Building Code of Australia

Assessment Report

**Project Address: Telopea Stage 1A, Lot 5-7 Sturt
Street, Telopea**

Revision: R04

DRAWING TITLE
BASEMENT 01 PLAN

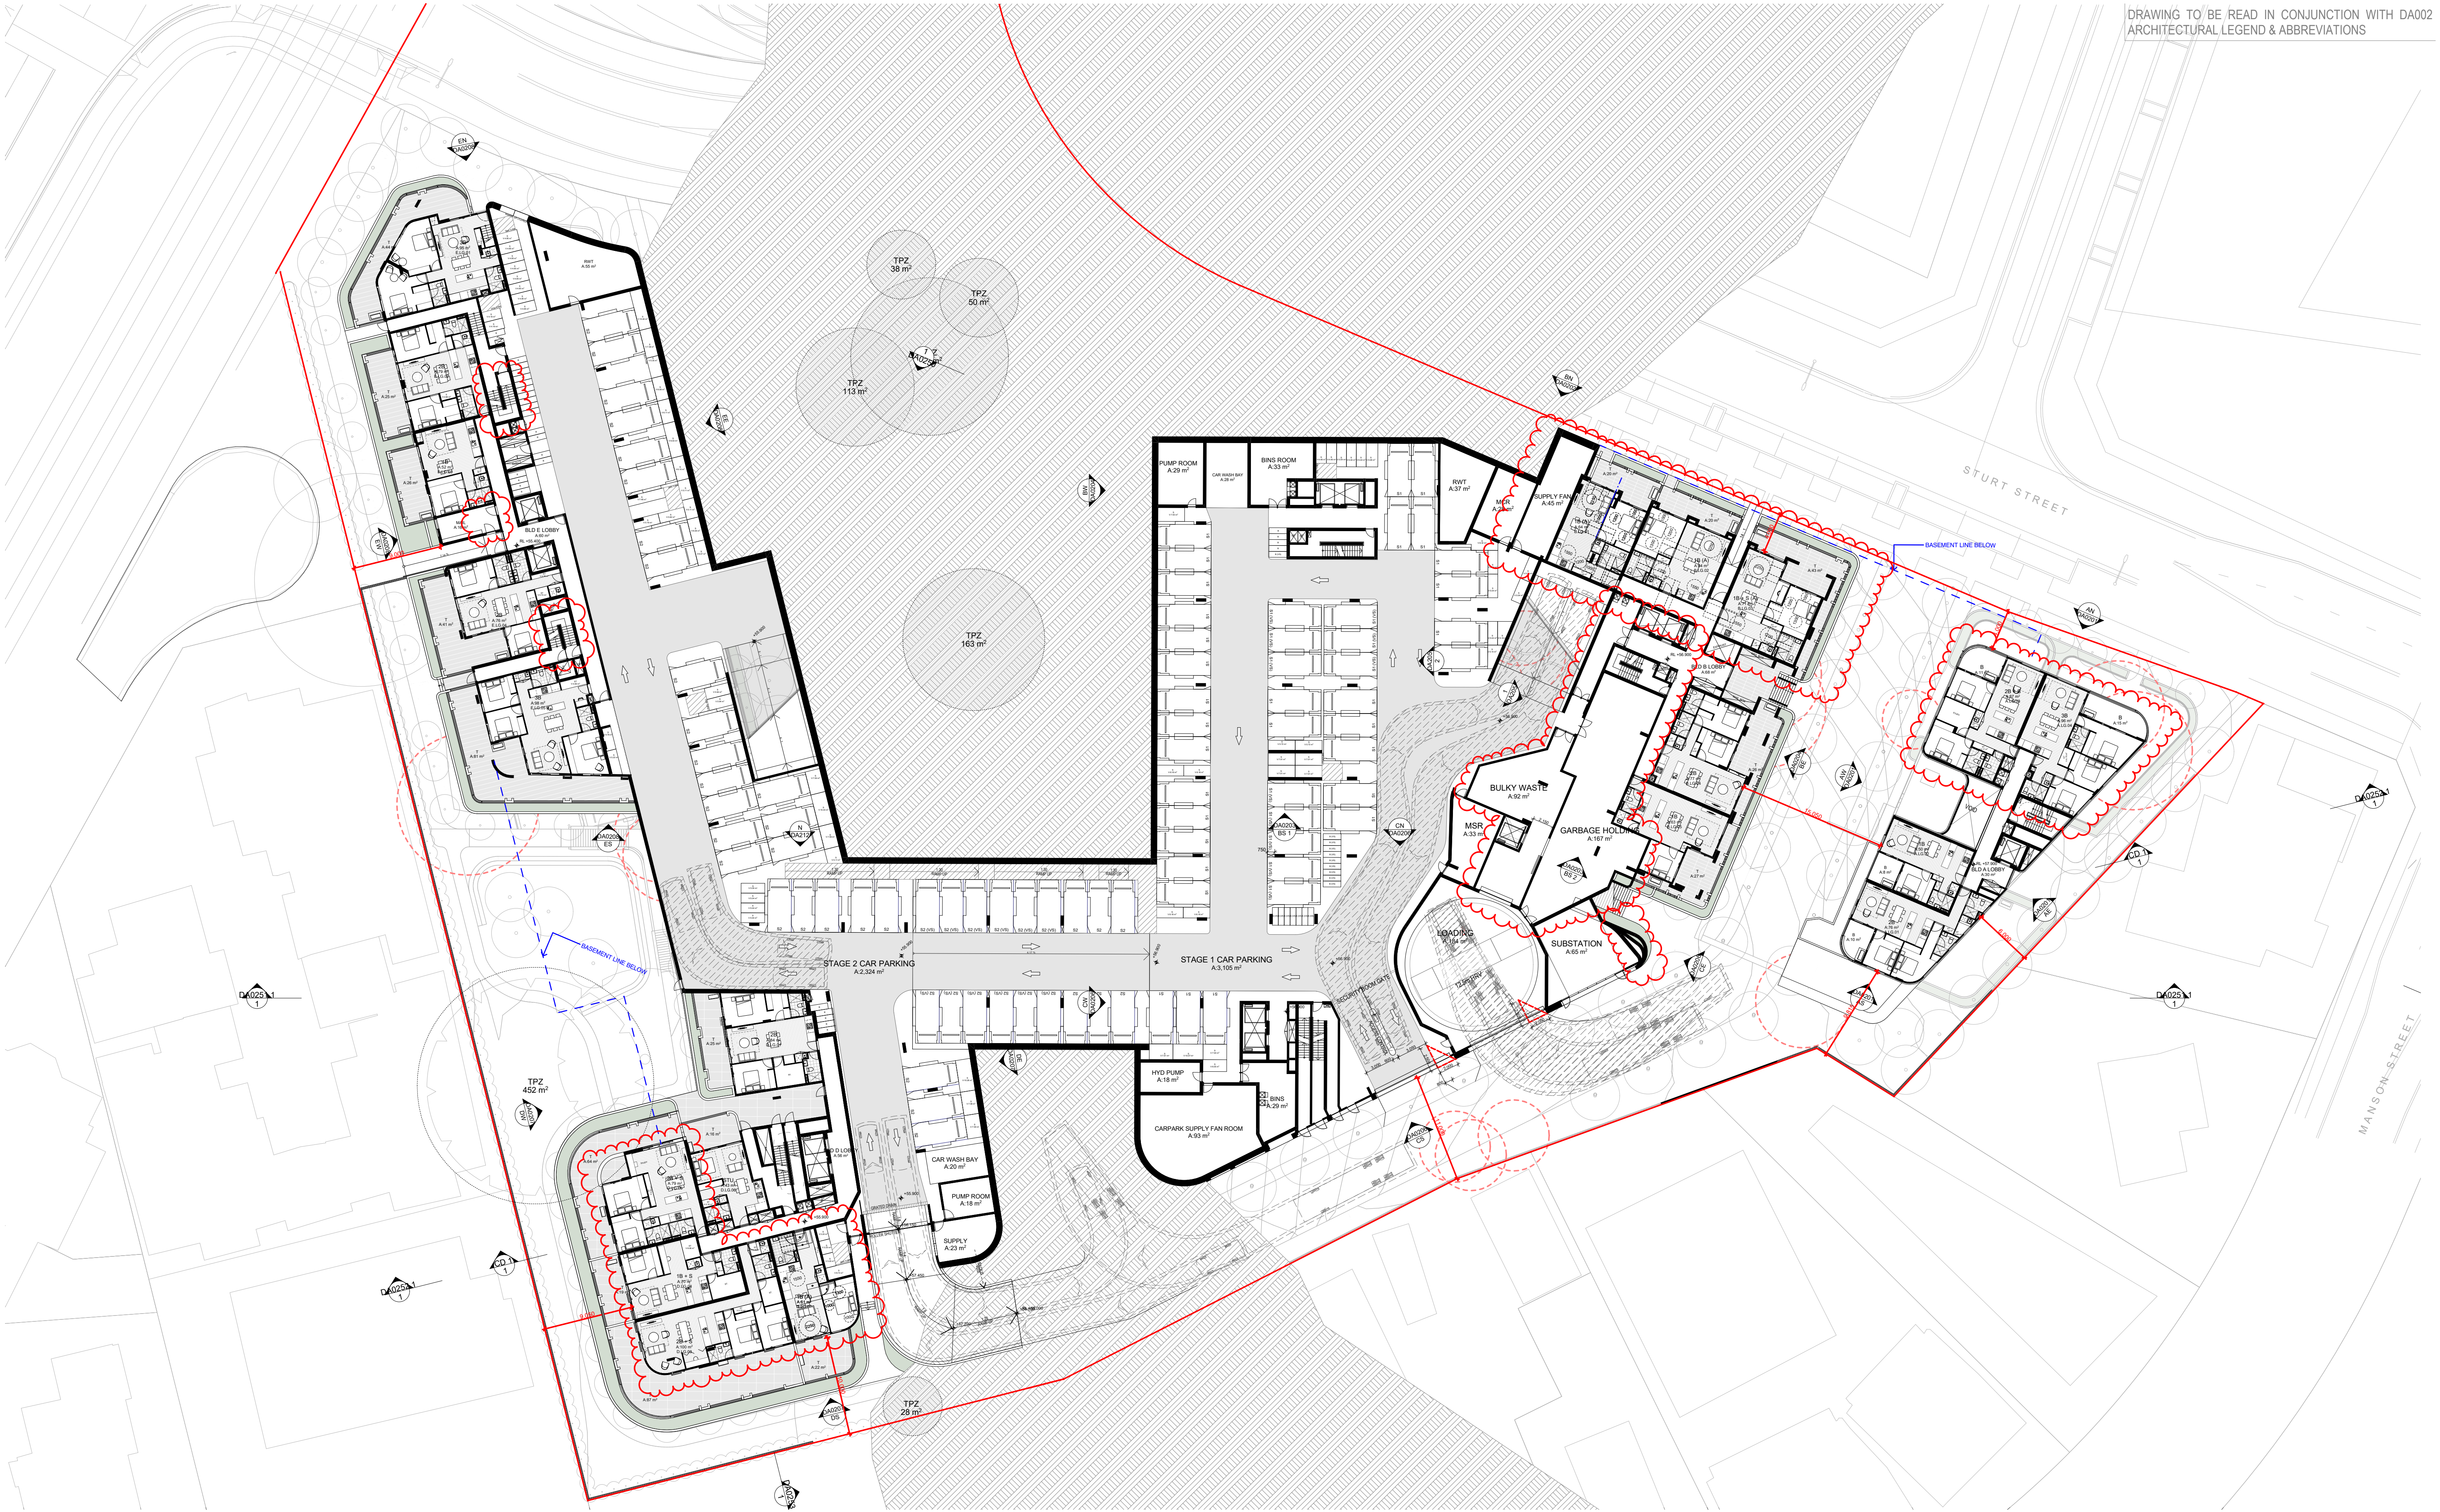
Clause	Performance justification
	 Example of public corridor exceeding 40m
D2D3 Number of exits	The building is required to be provided with a minimum of two exits from each part. The following areas contain only one exit from each storey or part: Basement 01 - Fire Pump Room (B01)  Tower A - The lobby areas (LG -L2)  - Level 8, hot water plant room has only one exit require performance justification. Tower B

DRAWING TITLE
UPPER GROUND FLOOR
PLAN

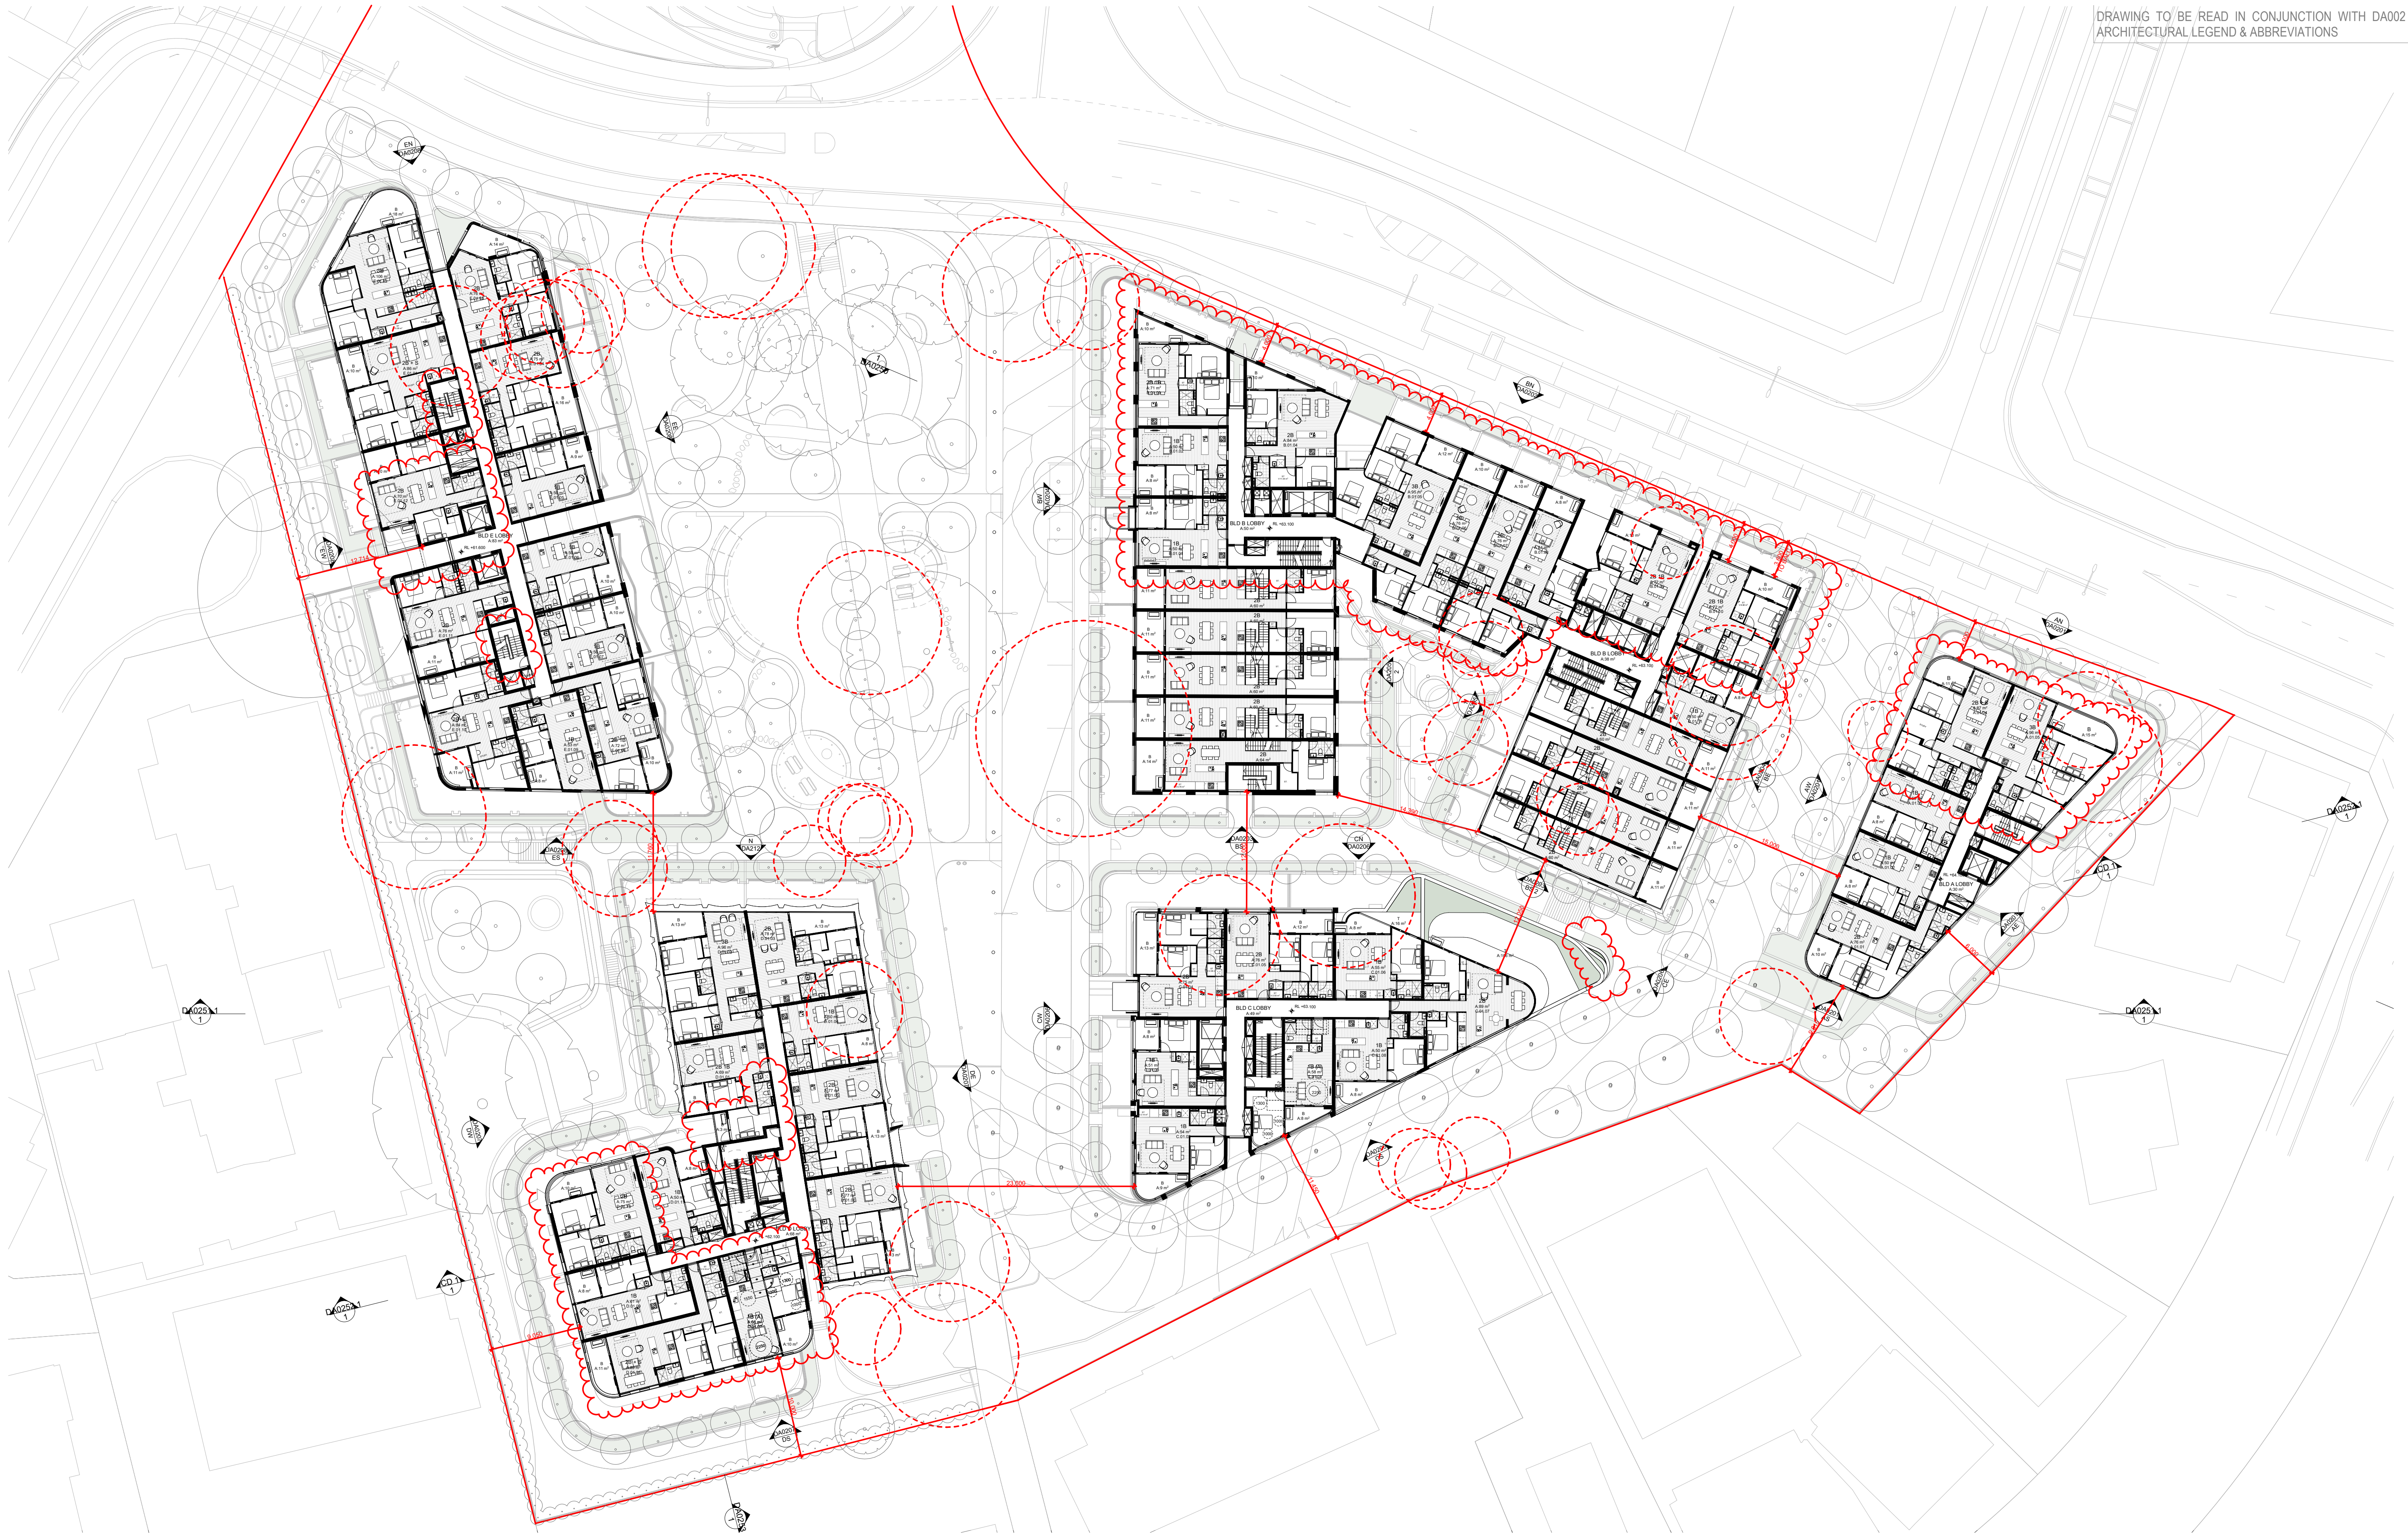
Clause	Performance justification
C3D15 Public corridors in Class 2 and 3 Buildings	The following public corridors exceed 40m without smoke proof walls: Tower B - Upper ground floor Approx. 53 - L2 Approx. 48.2m. Tower D - Upper ground floor Approx. 46m. Tower E - Upper ground floor Approx. 57m - L1 – L8 Approx. 51.4m..

Clause	Performance justification
	The fire isolated exits serving tower C – Approx. 8.7m in lieu of 9m. 
D2D12 Travel via fire isolated exits	D2D12(1) – Permit room to open directly to fire stair- Performance Solution to address DtS non-compliance.
	D2D12(2) - The following areas requires a Performance Solution to permit FIS discharge into covered area that is not open to 1/3 of its perimeter: Tower D FIS discharge in covered area approx. 3.21m open in lieu of 5.13m (LG) 
	D2D12(3) – The following walls and openings are located within 6m of the discharge pathway: Tower B 6 x FS exits with discharge at UG varies between 0.65m - 6m

Clause	Performance justification
	 Tower D 3 x FS exits with discharge at LG Approx. 2.34-4.2m 
D2D15(4)	The following exits are not located as far apart as practical. Performance justification is required. Tower B - The two residential stairs (western) are located adjacent to each other (UG). - The two residential stairs (eastern) are located adjacent to each other (UG). Tower C - The two residential stairs are located adjacent to each other (LG).
E1D2 Fire hydrants	The fire hydrant booster is located adjacent the entry to Tower A and is not located within sight of the main entrance into the building and not facing the street, noting that there are multiple pedestrian entries. Hydrant located on floor (i.e not within fire isolated exits or within 4m of a non-fire isolated exit) within the carpark to achieve coverage are required to performance satisfied.
E1D15 Fire control centres	There is a technical non-compliance as the fire control room is in Tower A and is not located from the front entrance of the building given there are multiple entries. Performance justification will need to address this.
